# Kanata North

**Concept Plan.**

Second Submission.

2559688 Ontario Inc.

Figure 16 Trails and Pathways Diagram

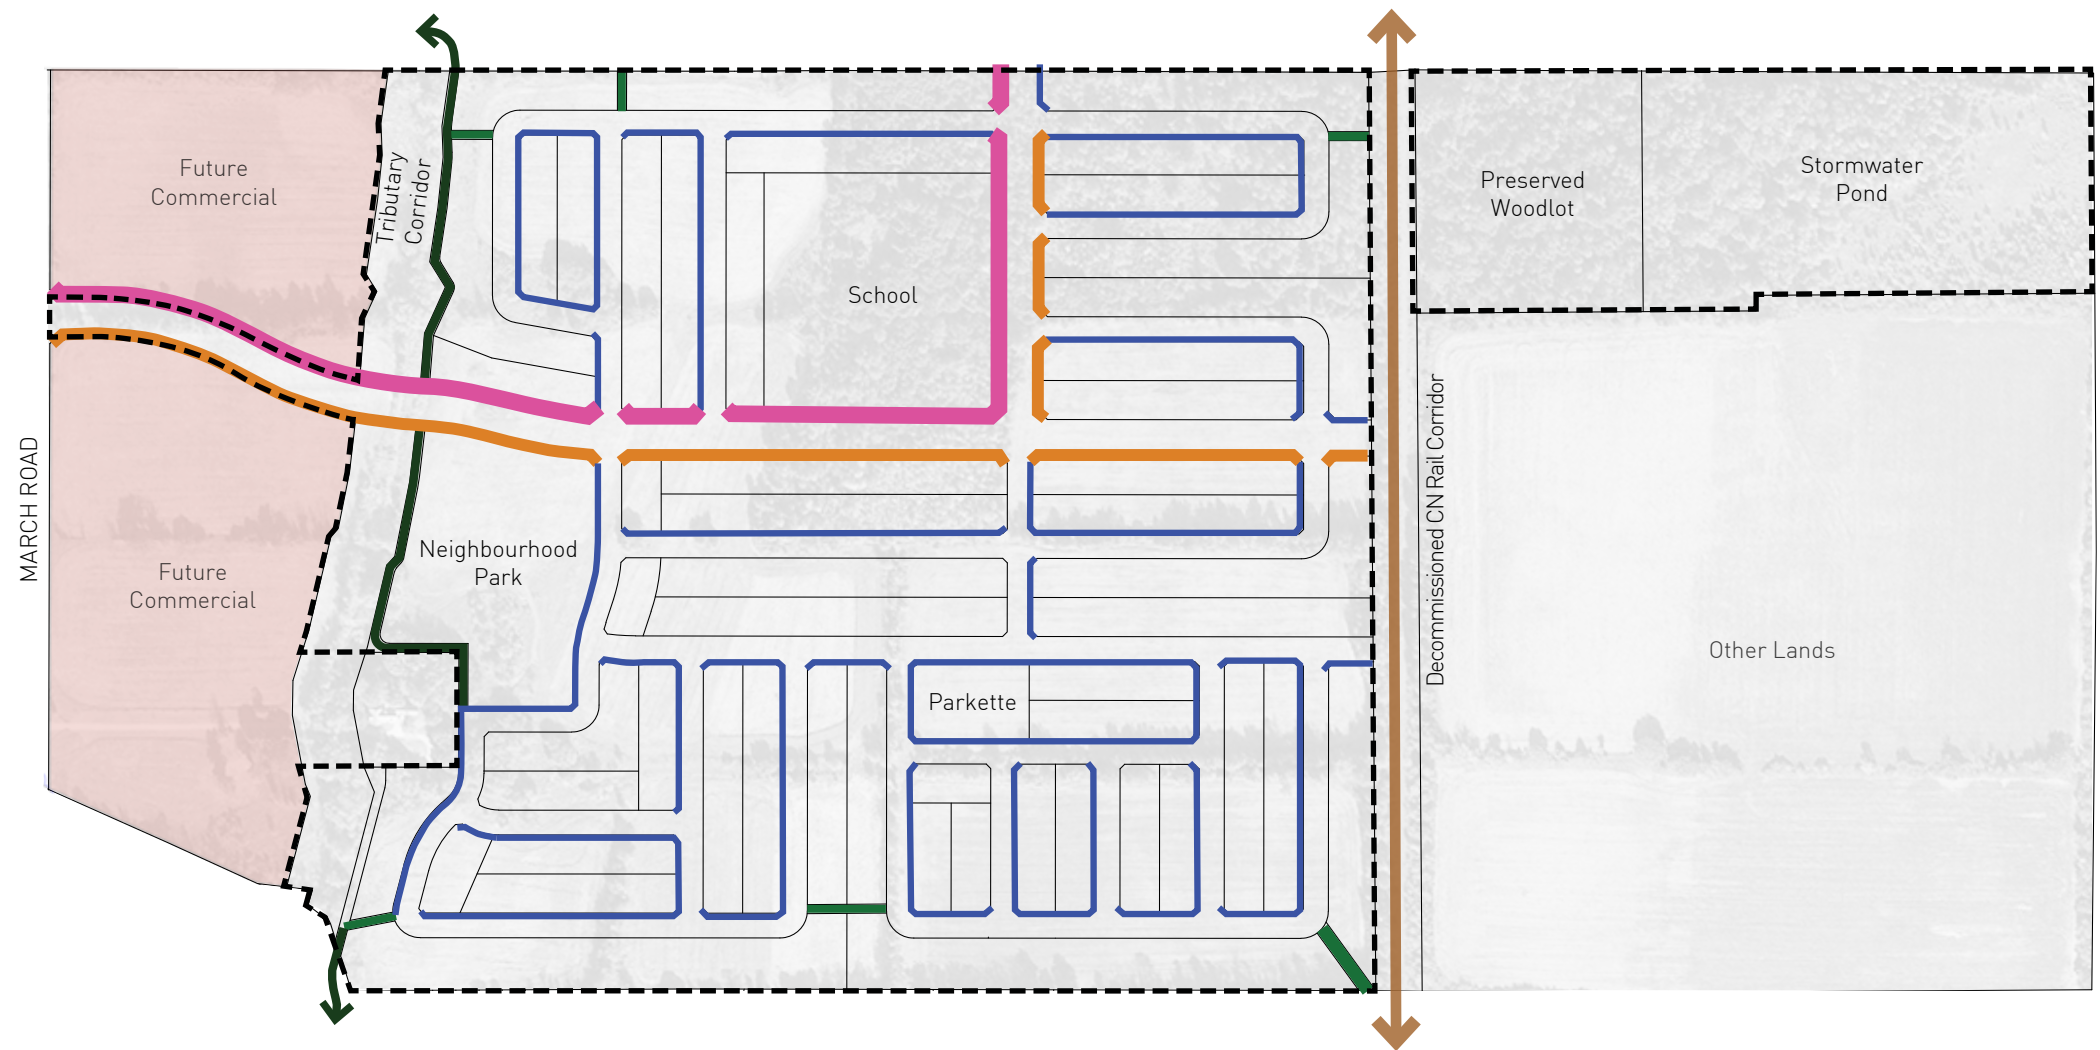
13 Please include sidewalk on the south side of block 26. Please update the sidewalk plan in the concept plan booklet (pg 25). This will be referenced to draft the sidewalk conditions. The cross section on pg 33 is showing sidewalk on both sides.

14 Minimum sidewalk width should be 1.8m.

Figure 23 Minor Neighbourhood Collector (Typical 24.0m ROW)

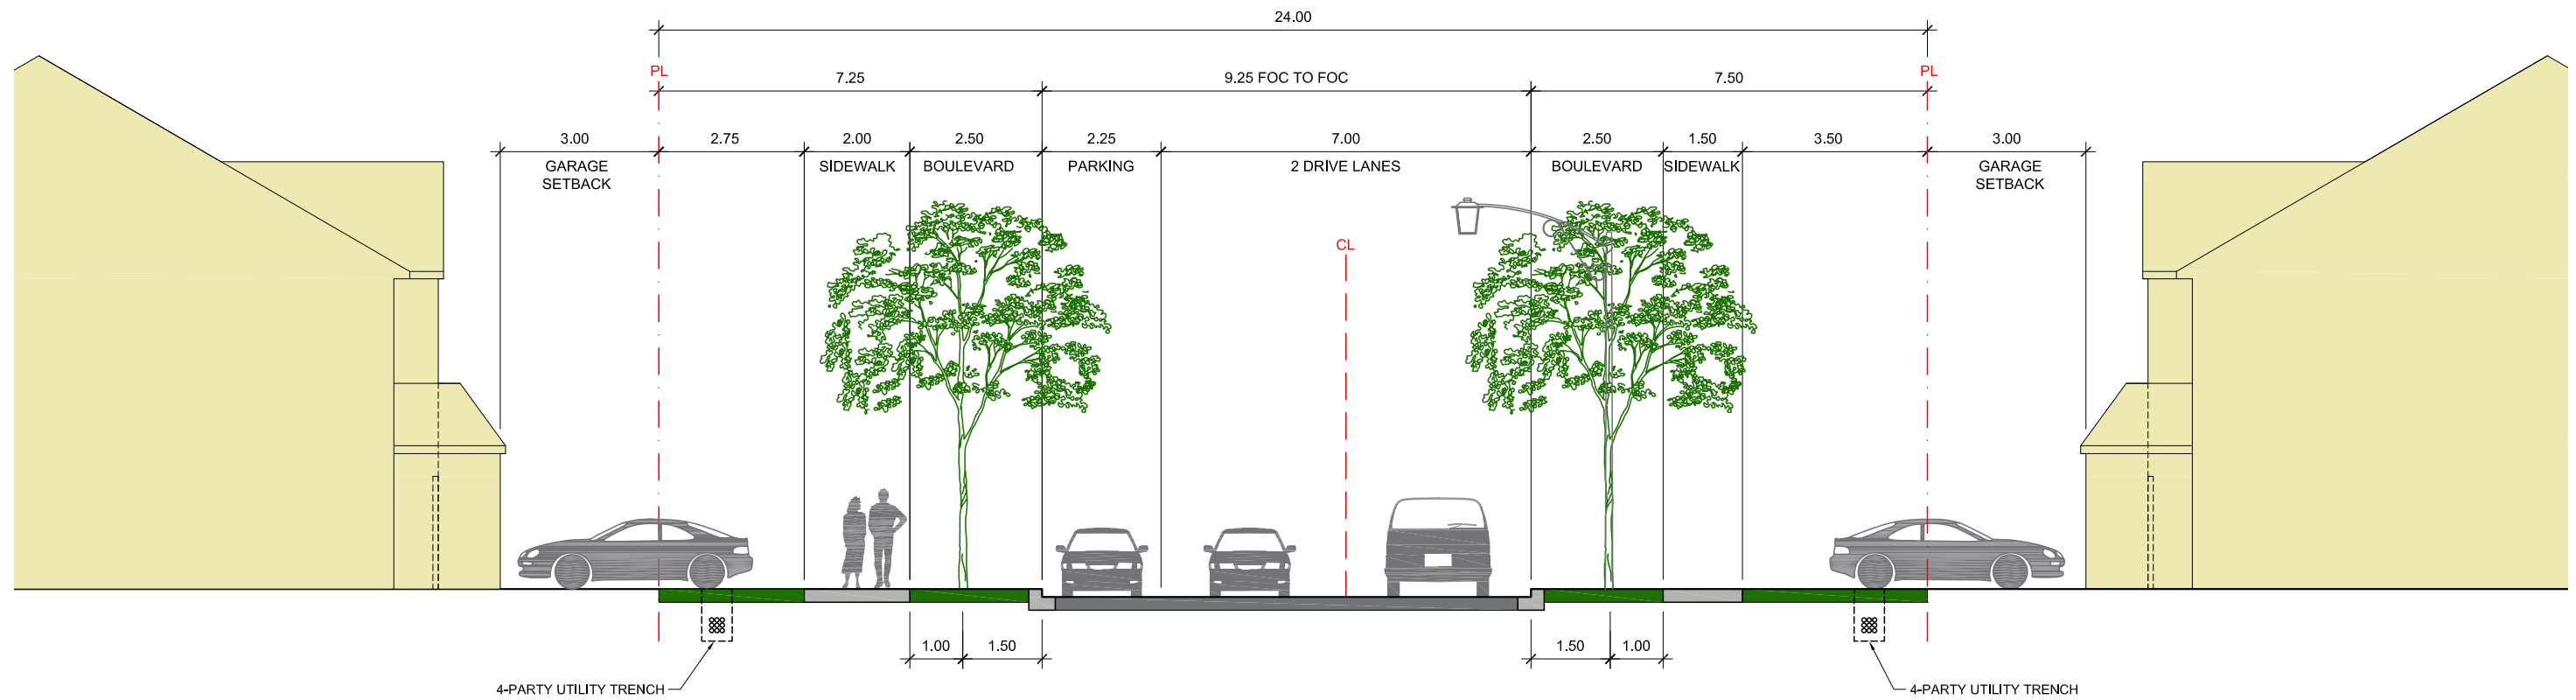
14 Minimum sidewalk width should be 1.8m.

Figure 24 Local Road (Typical 16.5m ROW)

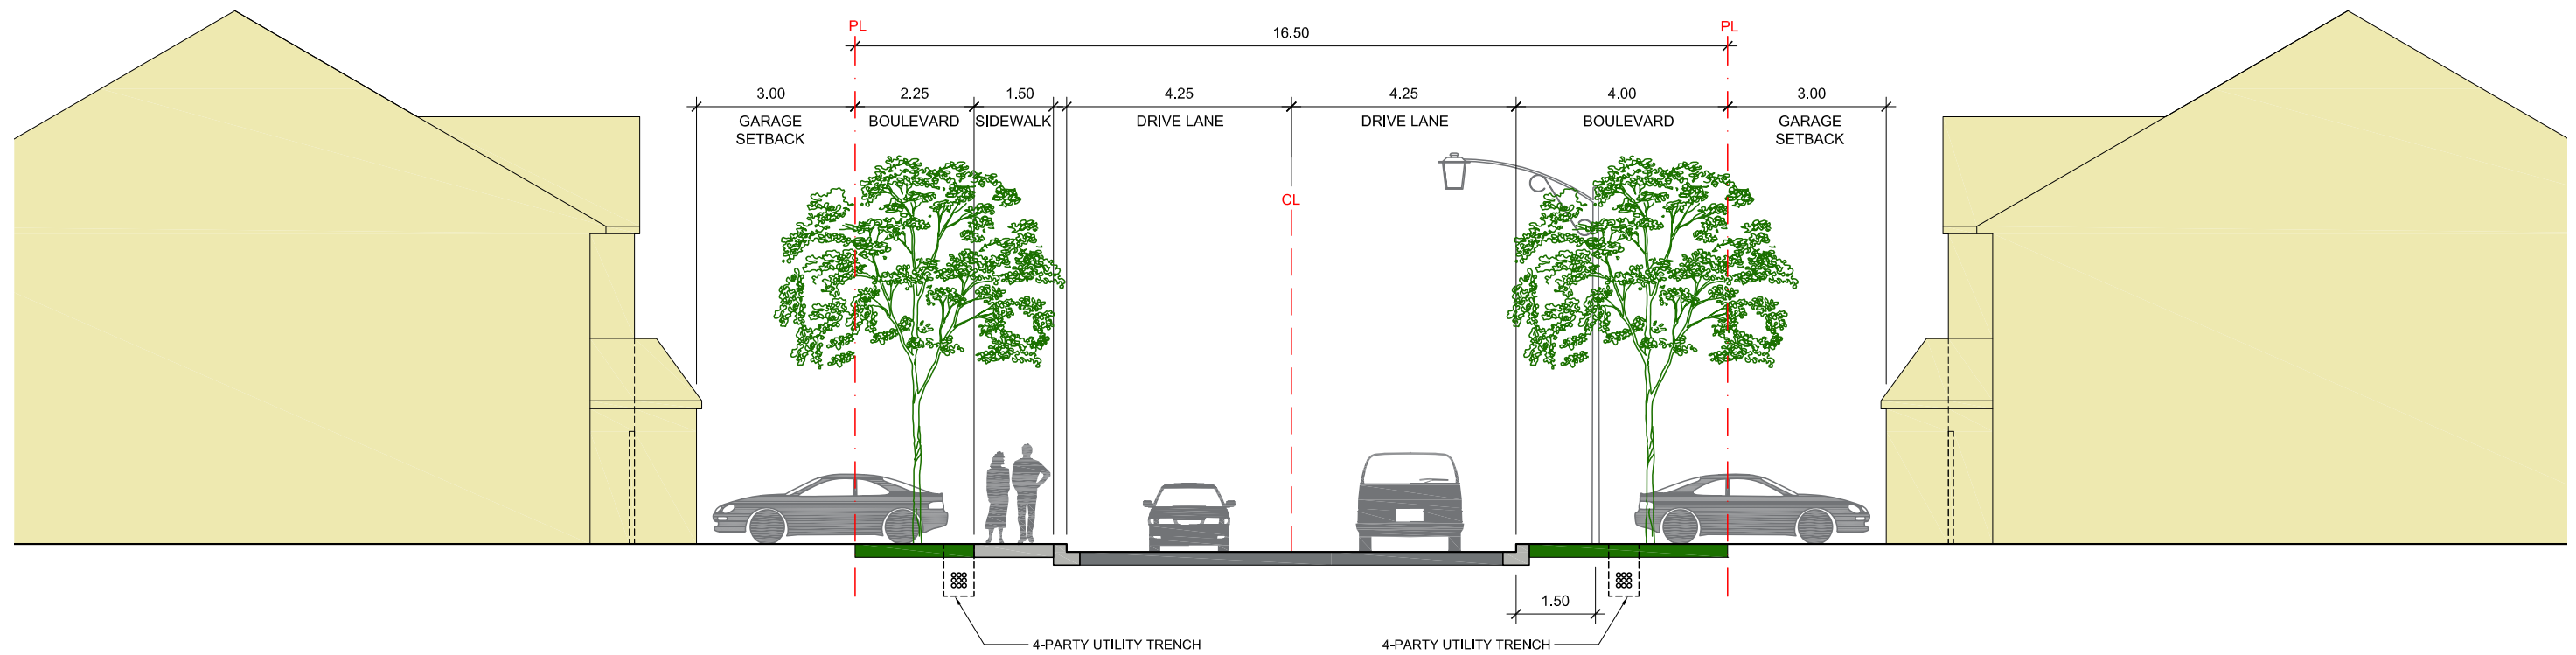
- 14 Minimum sidewalk width should be 1.8m.
- 25 Please confirm that a 3 m front and corner side yard setback is adequate when combined with a 16.5 m r.o.w. to allow for tree planting at 4.5 m from the foundation.
- 91 As per the CDP, A 16.5m right-of-way may only be considered where soil conditions will permit planting of street trees within the reduced right-of-way.

- 14 Minimum sidewalk width should be 1.8m.
- 25 Please confirm that a 3 m front and corner side yard setback is adequate when combined with a 16.5 m r.o.w. to allow for tree planting at 4.5 m from the foundation.
- 91 As per the CDP, A 16.5m right-of-way may only be considered where soil conditions will permit planting of street trees within the reduced right-of-way.
